RFI #: 68  
Date: 2/29/2012  
Job: EB-02 Keller Springs Lofts  
Phone: 877-777-5115

Subject: Purposed change to the elevator detail on 9/S3.01

RFI #: 108  
Date: 4/11/2012  
Job: EB-02 Keller Springs Lofts  
Phone: 877-777-5115

RFI #: 82  
Date: 3/21/2012  
Job: EB-02 Keller Springs Lofts  
Phone: 877-777-5115

S3.01

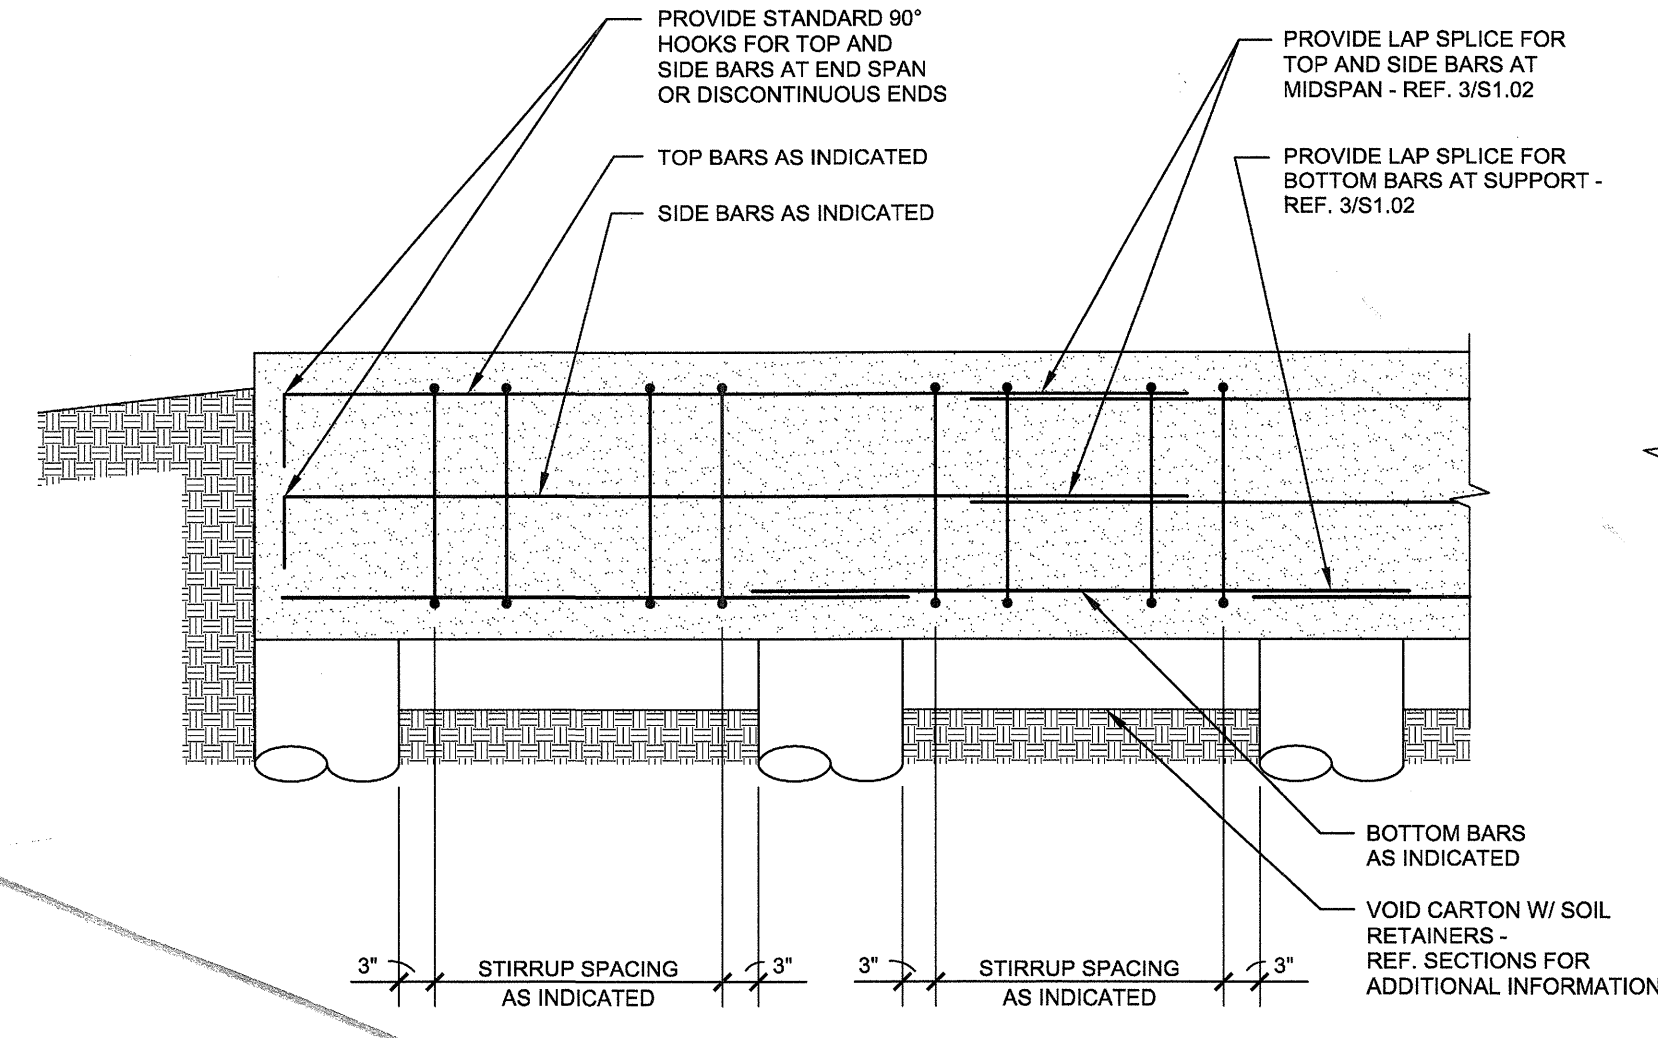
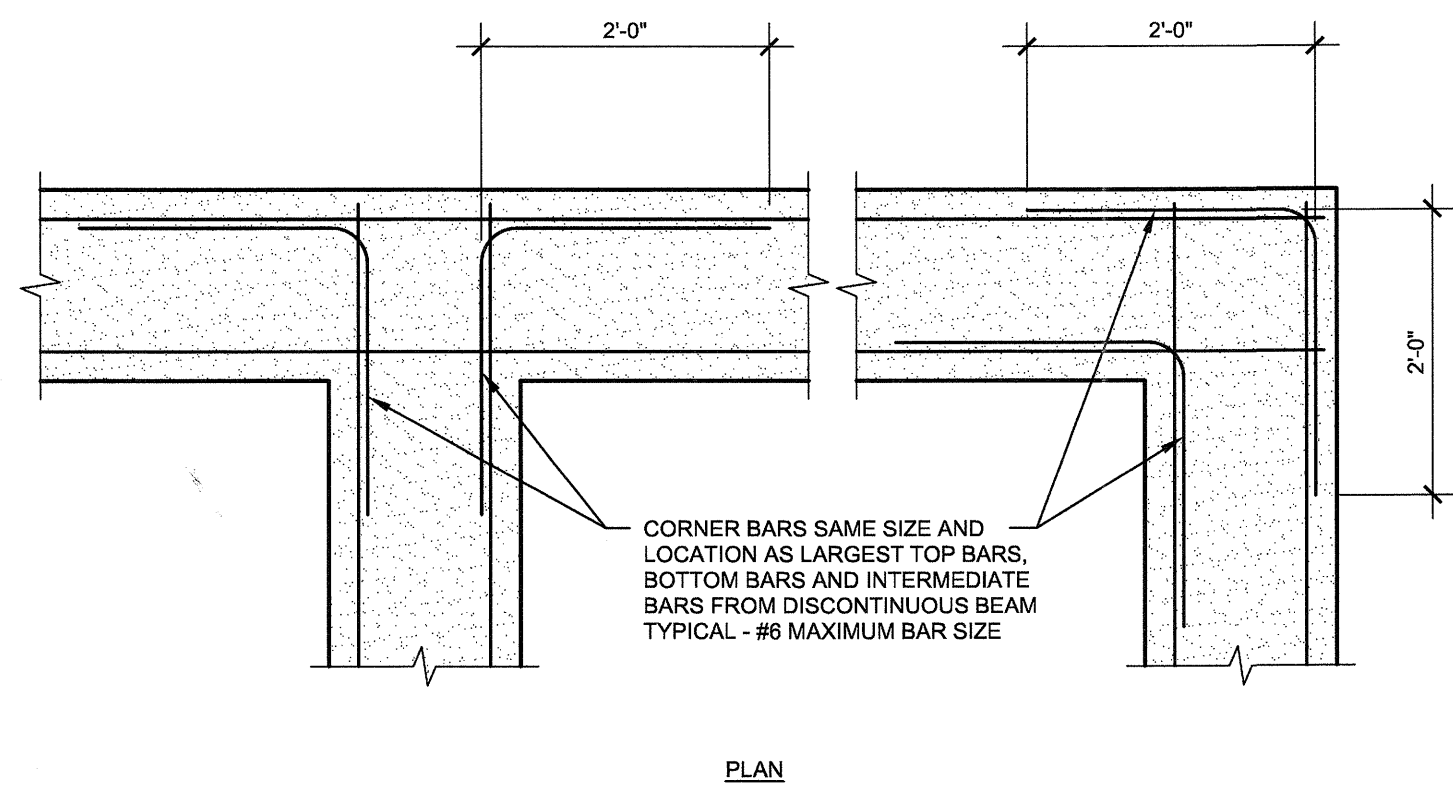
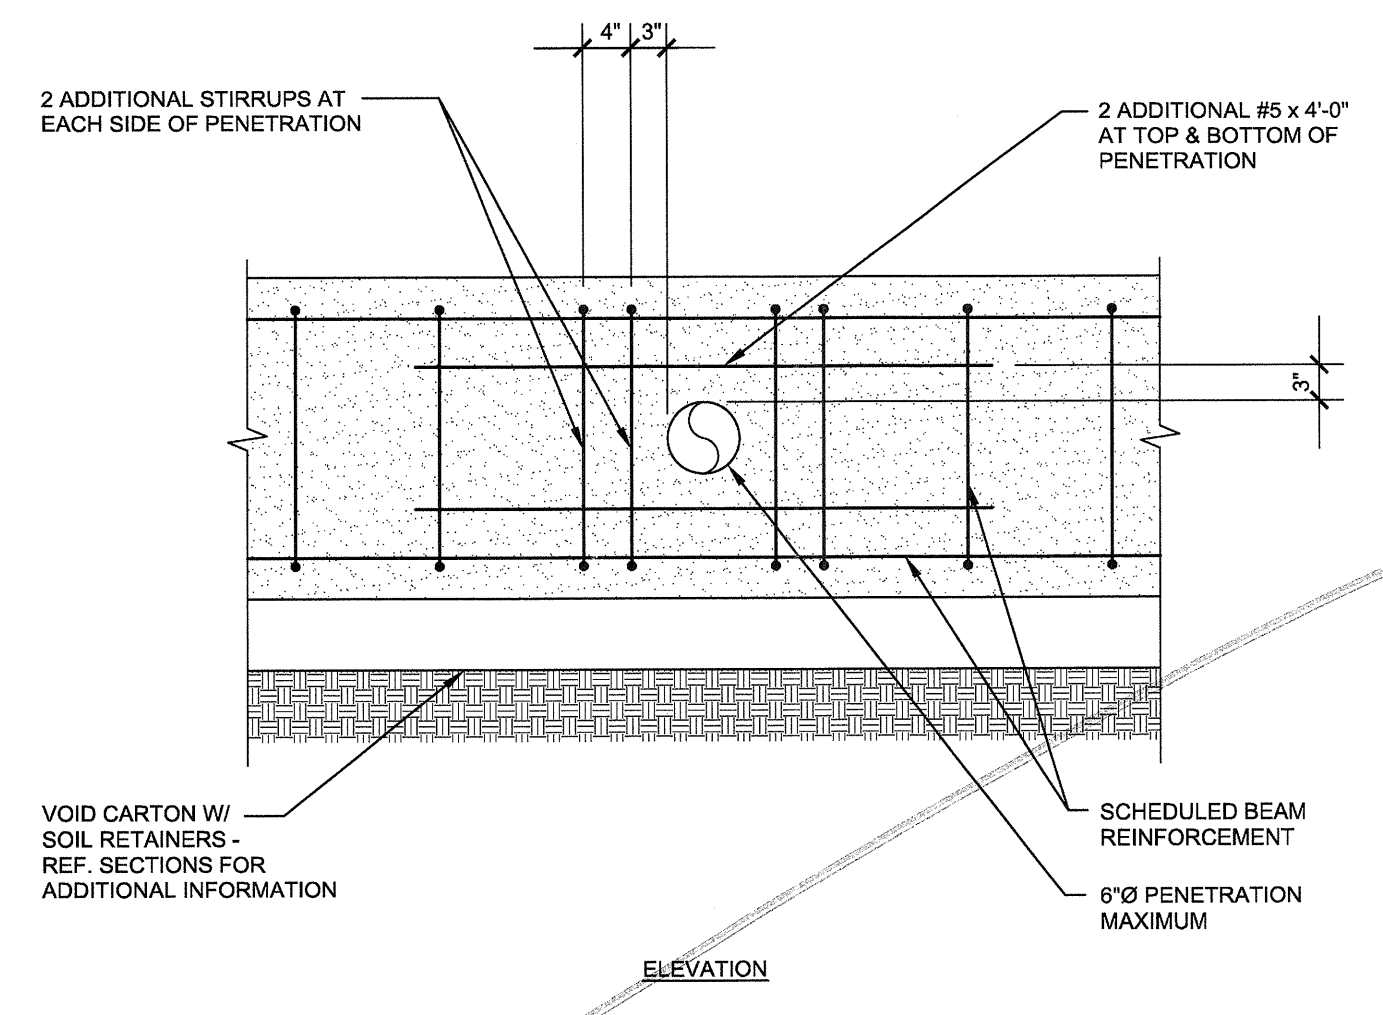
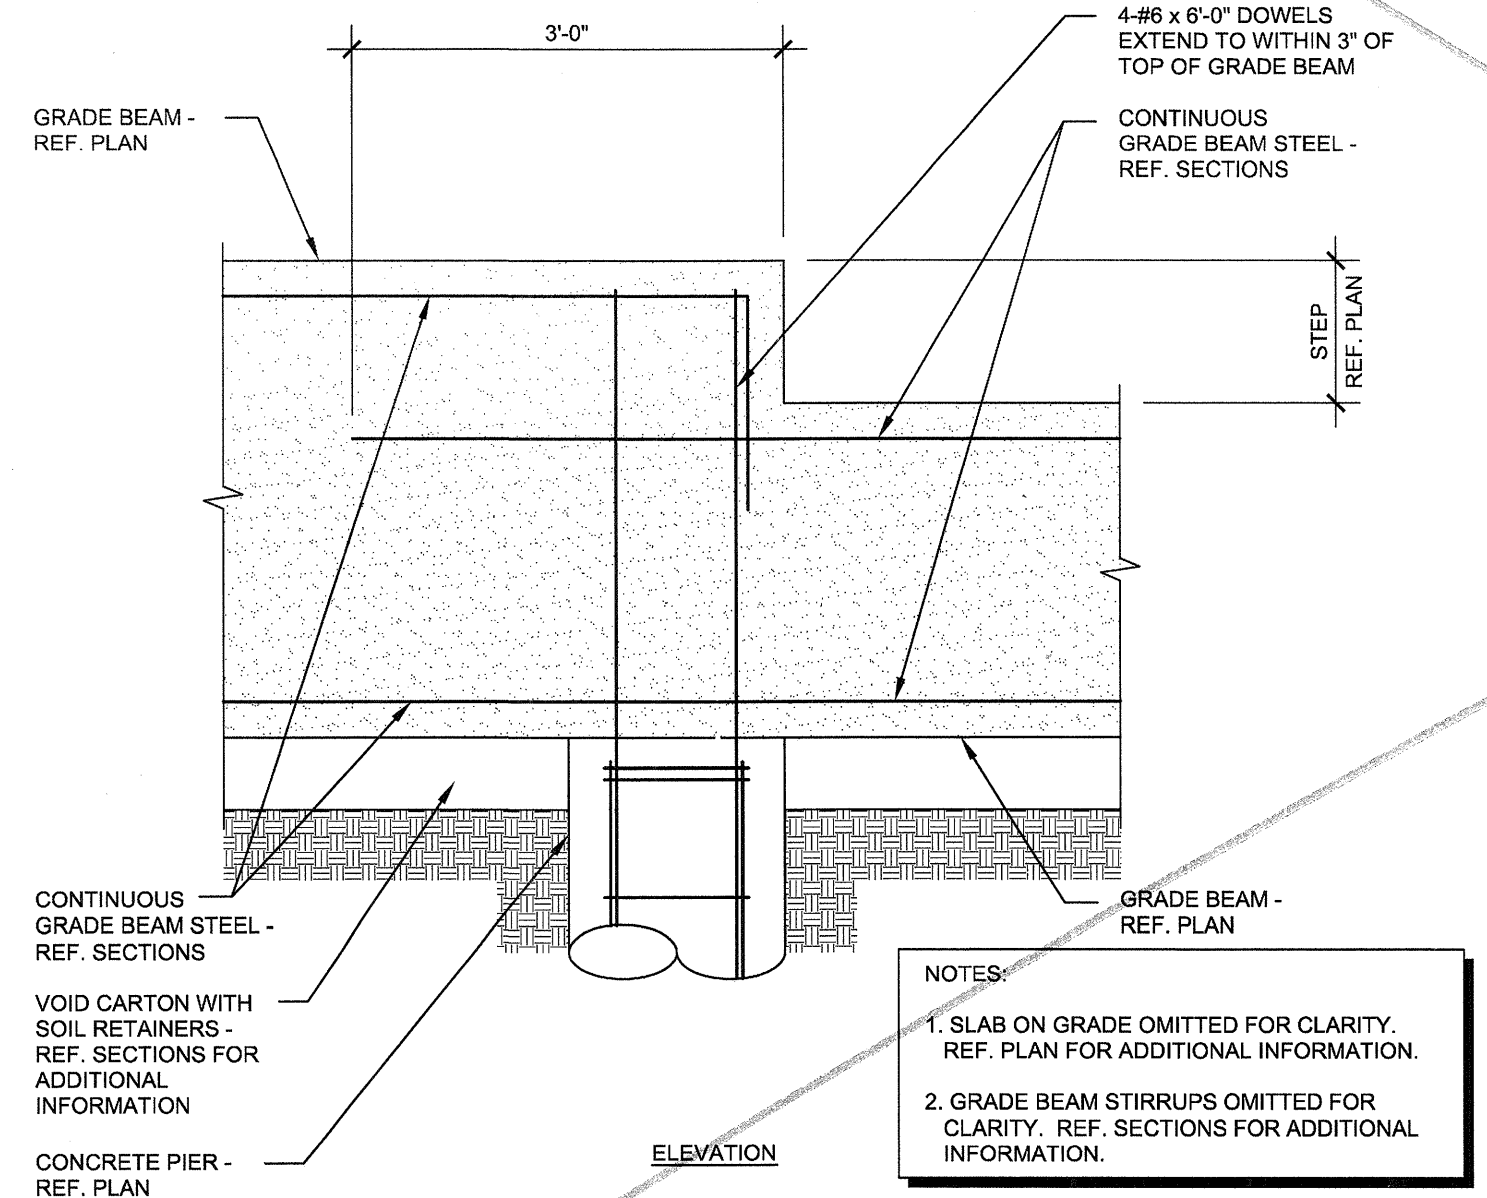
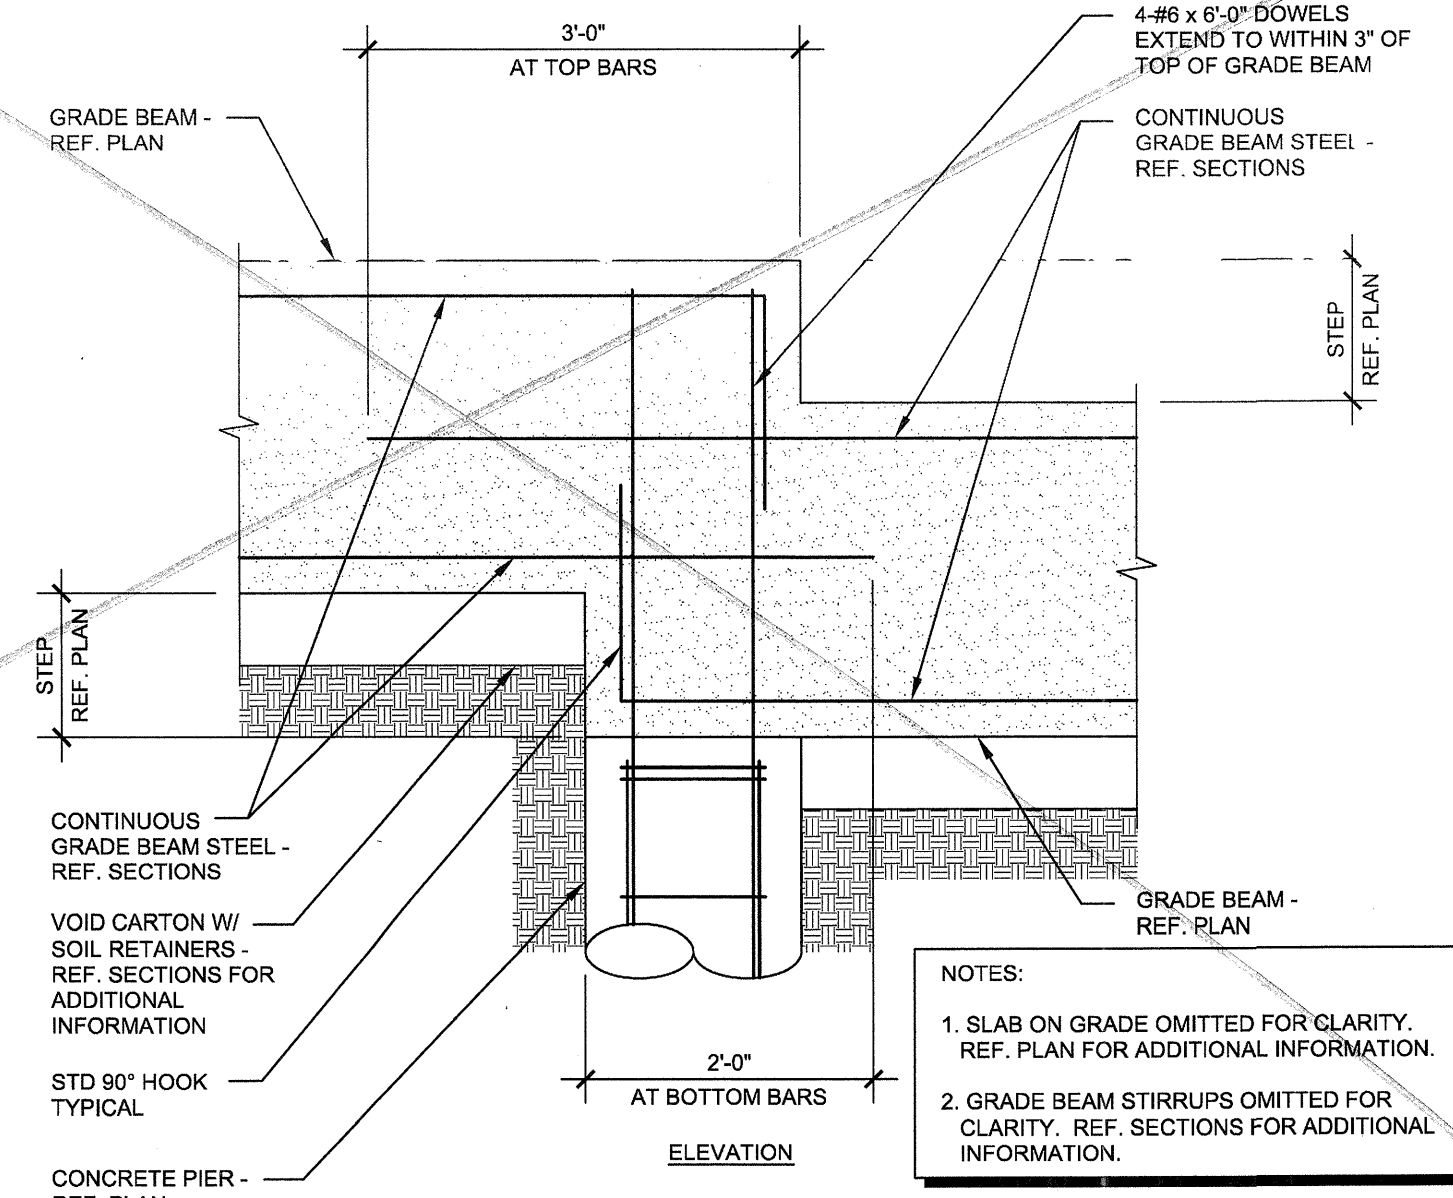
**Request:** Date Required: 3/7/2012  
We would like to purpose a change to the elevator detail on 9/S3.01. Can we pour the bottom 1st similar to the original detail on the construction issue plans (10-17-2011). The enclosed attachments have 9/S3.01 marked \*1. We have our proposed change marked \*2. Can you give us a detail the forms and pours like our \*2 detail.

Please see attached.  
R. Trent Perkins, PE  
Parkin-Perkins-Olsen Consulting Engineering, Inc.  
March 1, 2012

**Request:** Date Required: 3/22/2012  
In our meeting on 3/16/12 at your office we discussed the already poured piers on slab pour #1 as having 4-#6x5'-0" dowels as shown on 1/S3.01 vs the proper detail as shown on 3/S3.02, which requires 6 #7 dowels. You were going to check to see if we can reduce the required number of #7 dowels to go along with the in place #6 dowels.

Please provide 4 - 7 "L" dowels in addition to the 4-#6 dowels currently in place.  
R. Trent Perkins, PE  
Parkin-Perkins-Olsen Consulting Engineering, Inc.  
March 22, 2012
